Submission re Development Application for The University of Sydney Campus Improvement Program (CIP), State Significant Development (SSD 6123)

I write on behalf of Sydney Local Health District (SLHD), the owner and operator of Royal Prince Alfred Hospital (RPA), the direct neighbour on The University of Sydney's (UOS) western boundary, and therefore also on behalf of the NSW Ministry of Health/Health Administration Corporation.

01 HEALTH - PROPOSED ENVELOPE PLAN

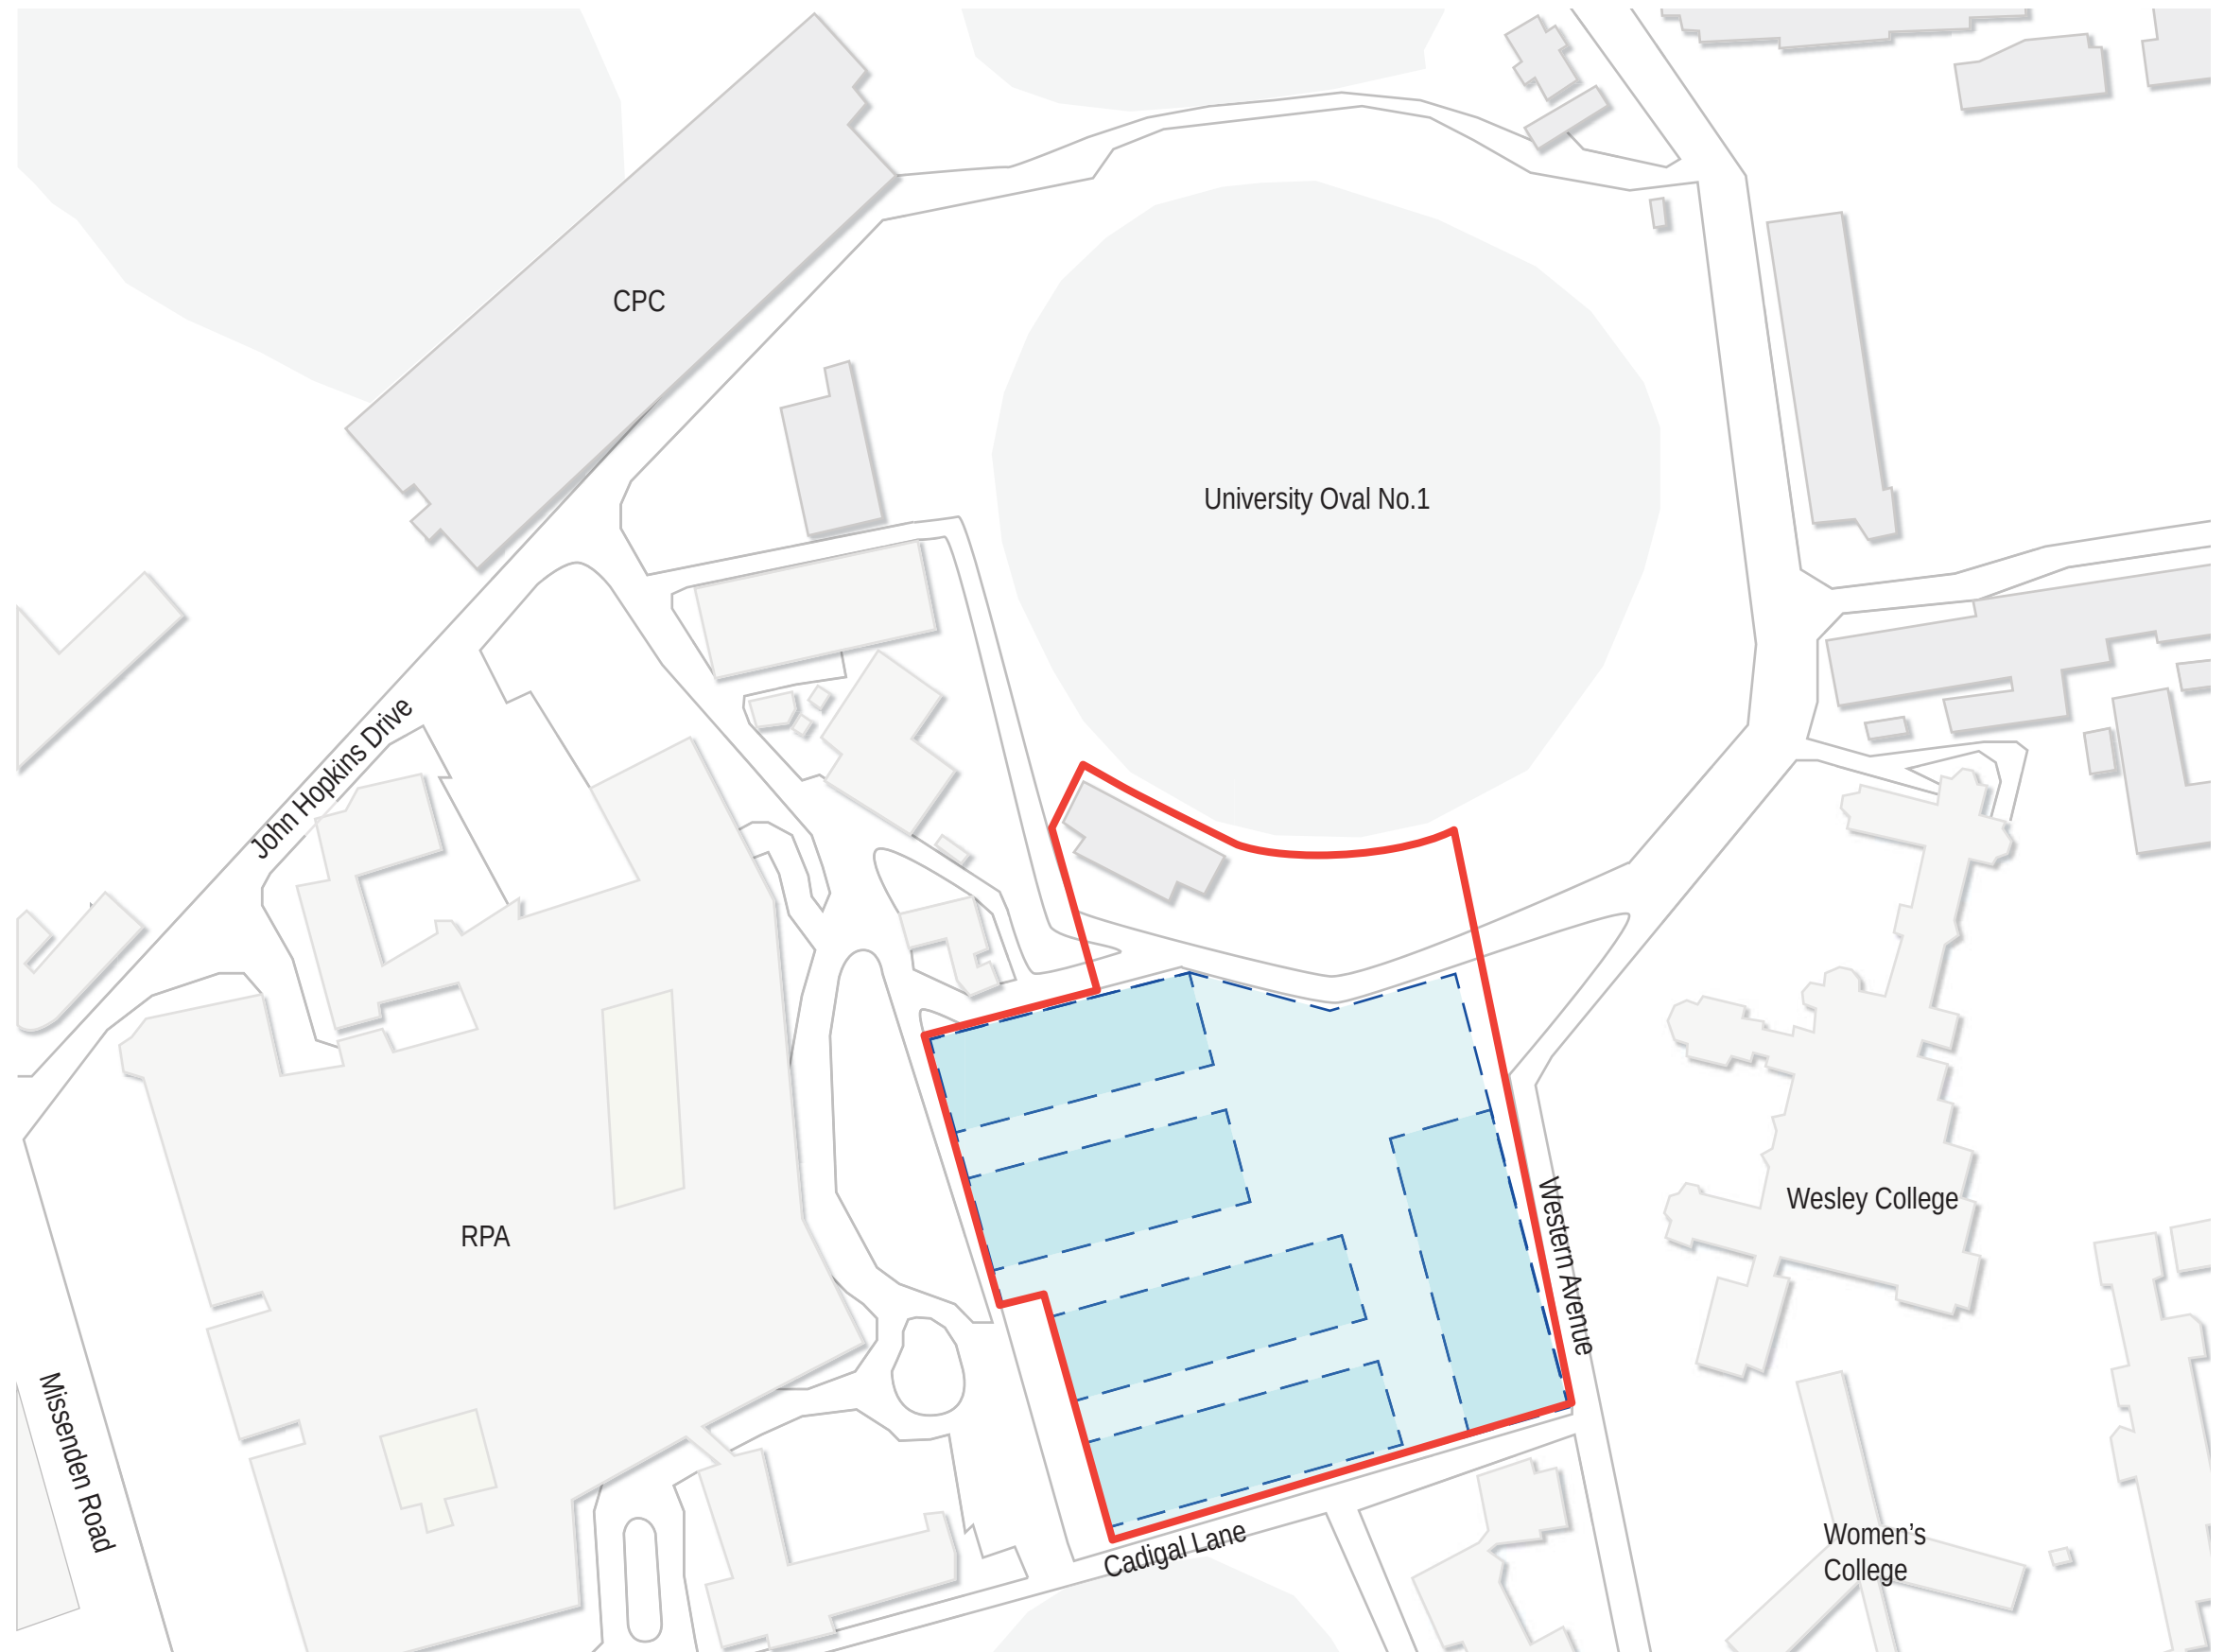
1. The proposal features tall buildings right on the boundary, and in part over the boundary, with RPA (see proposed building alignment west of the existing Bosch Building, Drwg No. SSD-E-11).

In some very early planning the University queried the possibility of improving the interface and perhaps better sharing the boundary. However the University has not specifically consulted us regarding this proposed encroachment by the development and there has not been any agreement. There has been preliminary and high level discussion regarding SLHD's vision to jointly plan the long-term future use of our shared boundaries, in particular for an Integrated Health Research Centre, otherwise known as an Academic Health Science Centre. Unfortunately those discussions do not appear to be reflected in this Health Precinct proposal and, if so in part, we are not familiar with its proposed composition.

2. Significantly, in the absence of shared and integrated planning along the boundary, RPA will be compelled in the future to extend its Clinical Services Building (CSB) into the area on RPA land between Gloucester House (heritage listed) and the proposed Health Precinct in order to meet with the very significant growing demand for services. The east campus of RPA represents a billion dollar investment on a fairly constrained site and, for cost efficiency, those services must be maintained on this side of Missenden Road and expand. It would be extremely problematic to have that opportunity curtailed by the CIP proposal, hence our desire to plan an integrated facility. Building the university's educational facility hard-up to the boundary has potential to limit the further development of RPA that is seeing the demand for services grow in the order of 15-30% over the next decade.

The Hospital could not agree to a proposal without setbacks without a shared long-term plan and mutually beneficial outcome including for the hundreds of thousands of patients who are treated annually at RPA, ie. our broader community and constituents of SLHD.

3. The construction of the Health Precinct as proposed, a set of buildings hard up on the boundary, has the potential to disrupt and risk the amenity of the RPA's east campus, in particular the historic and special area of trees and separation between the existing RPA inpatient building and the University's existing Blackburn Building currently on the boundary. Considerable planning and consultation is required here.
